Our Ref: AWE200083-L01: BCP/bcp
Contact: Dr Brett C. Phillips

22nd February 2021

RESPONSES TO FLOODING SUBMISSIONS, ASPECT INDUSTRIAL ESTATE, KEMPS CREEK, NSW

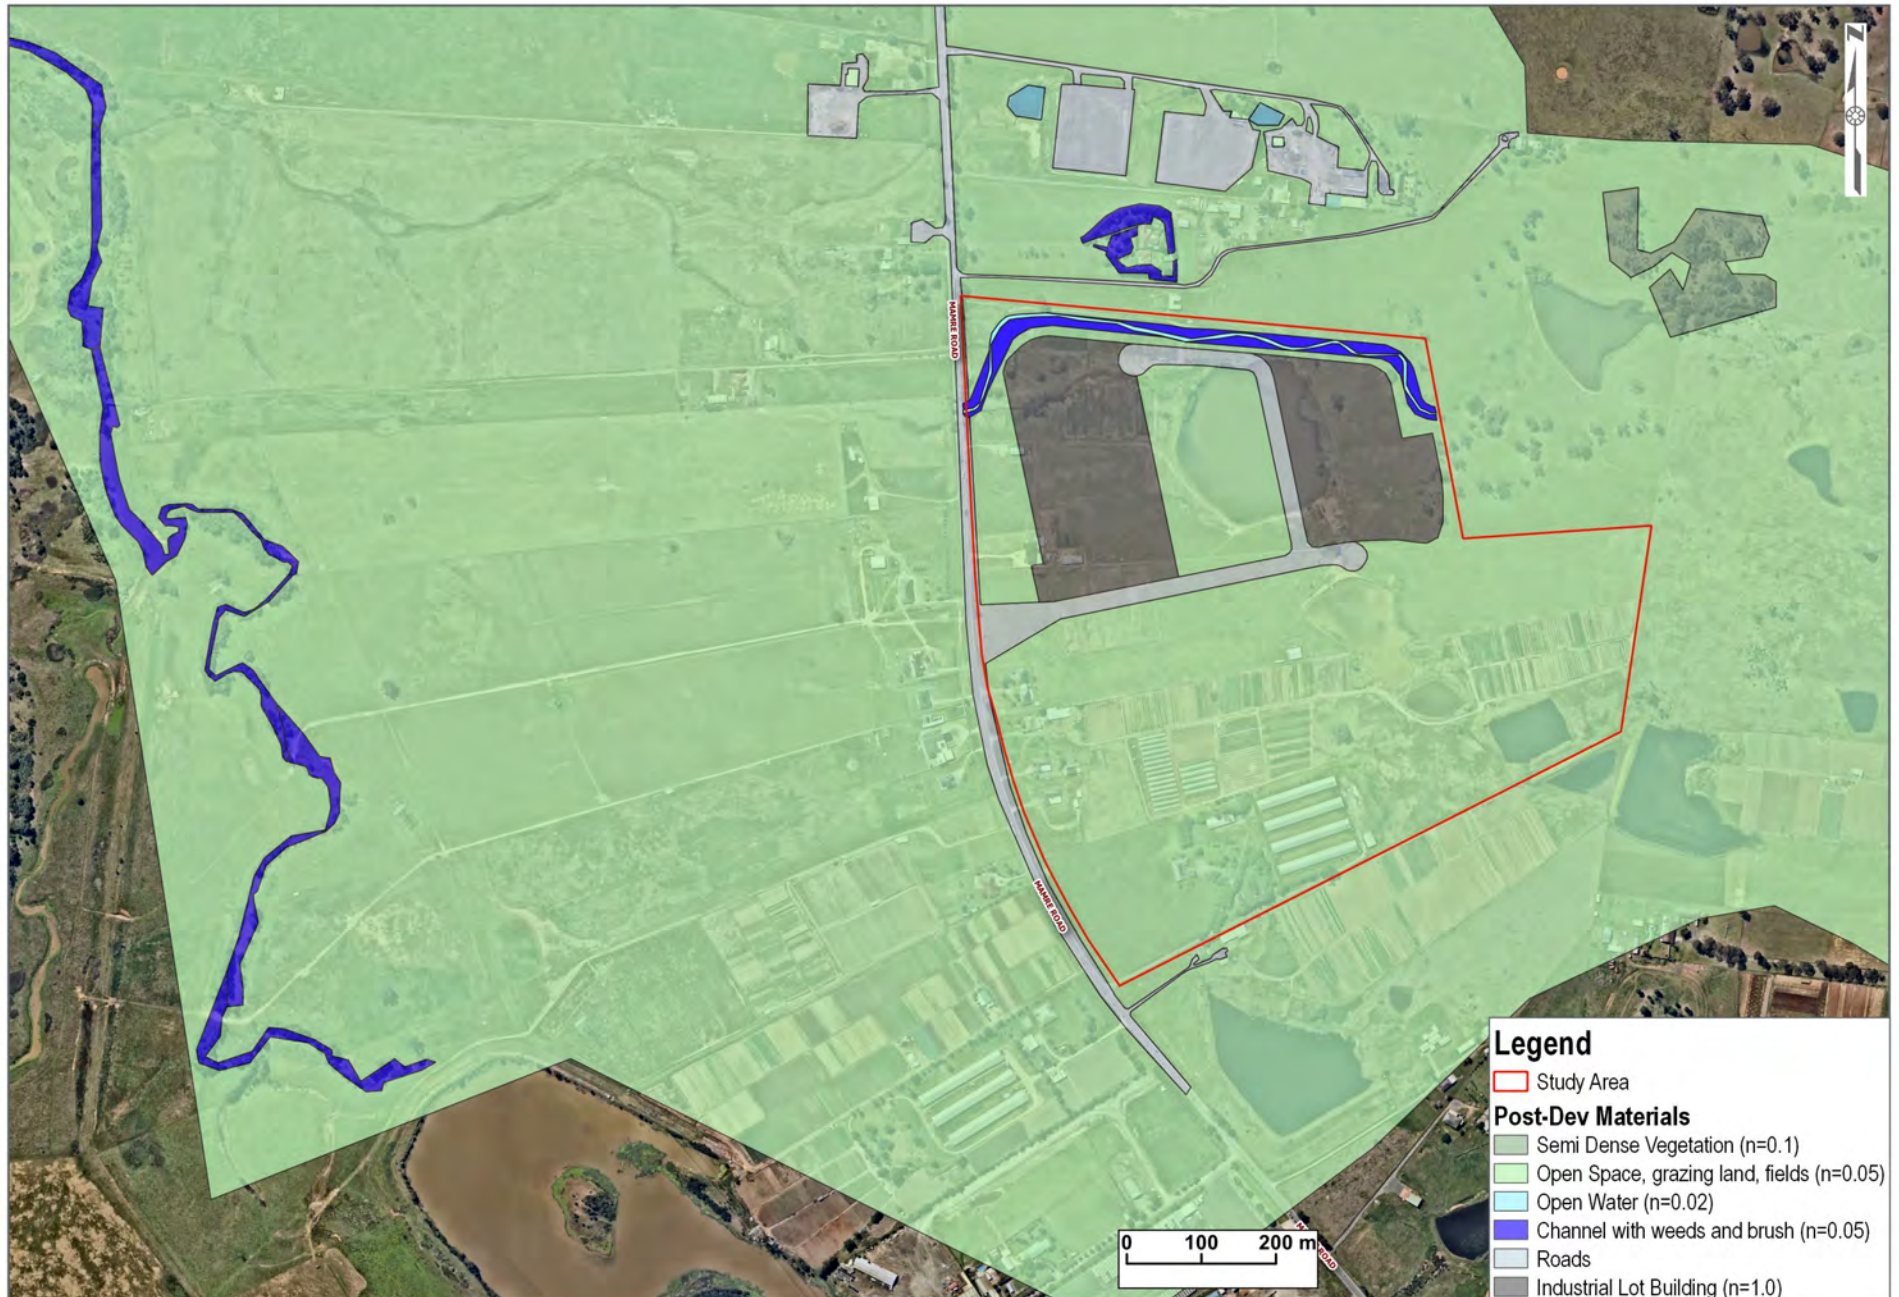
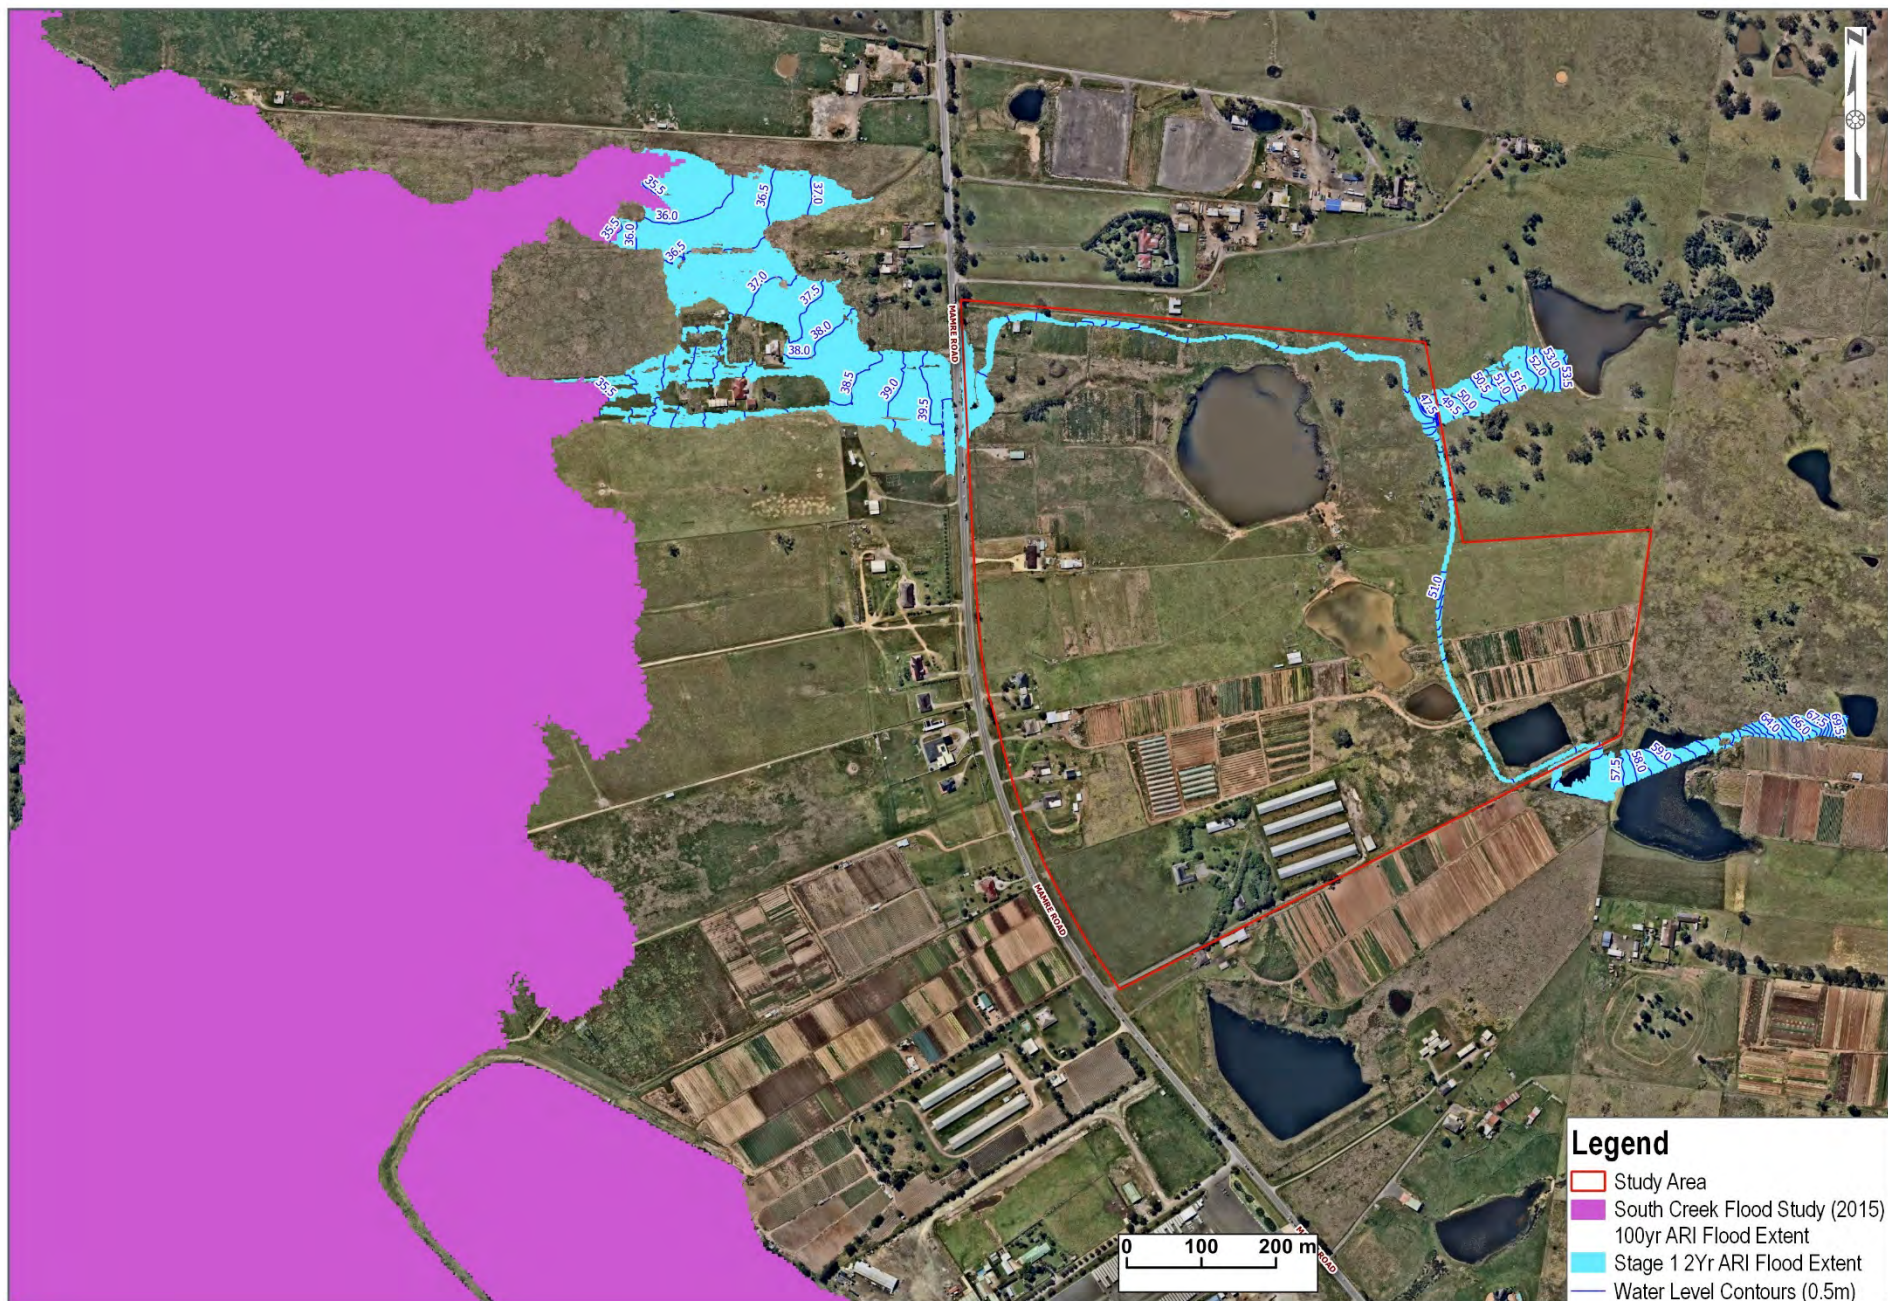
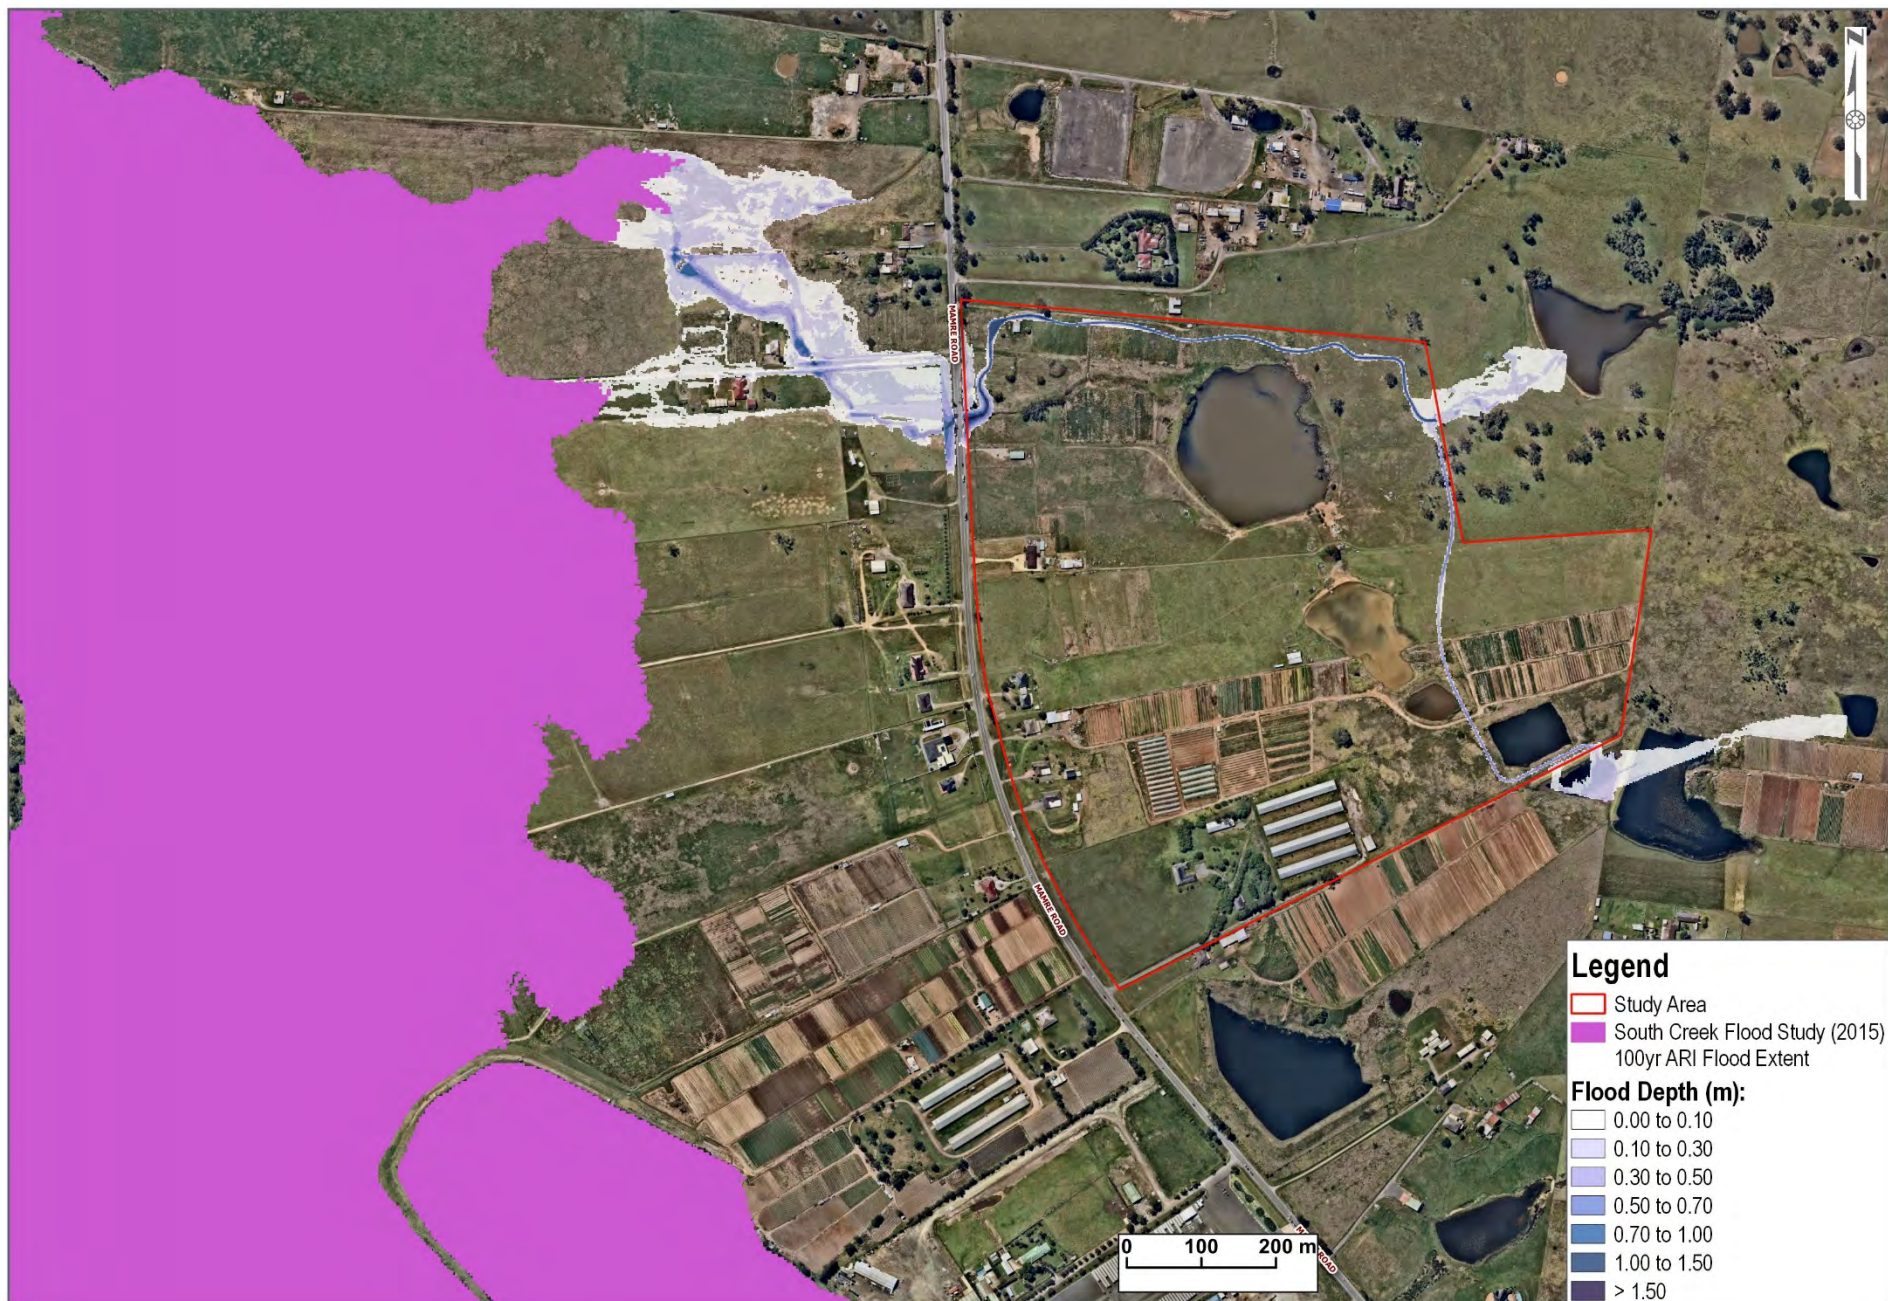
- *The developed scenario maps present local overland flow for Stage 1 which comprises of two industrial lots on the northern part of the site. However, from a flow management perspective, an overland flow study should consider the ultimate developed scenario of the site instead of considering each progressive development independently.*

- *All maps for developed conditions should properly depict the layout of the development, locations of proposed constructed channels and the location of the proposed detention basin.*

The final masterplan has been assessed and the results of the assessment have been incorporated into an updated version of the FIA report.

The updated Figures have been incorporated into an updated version of the FIA report.
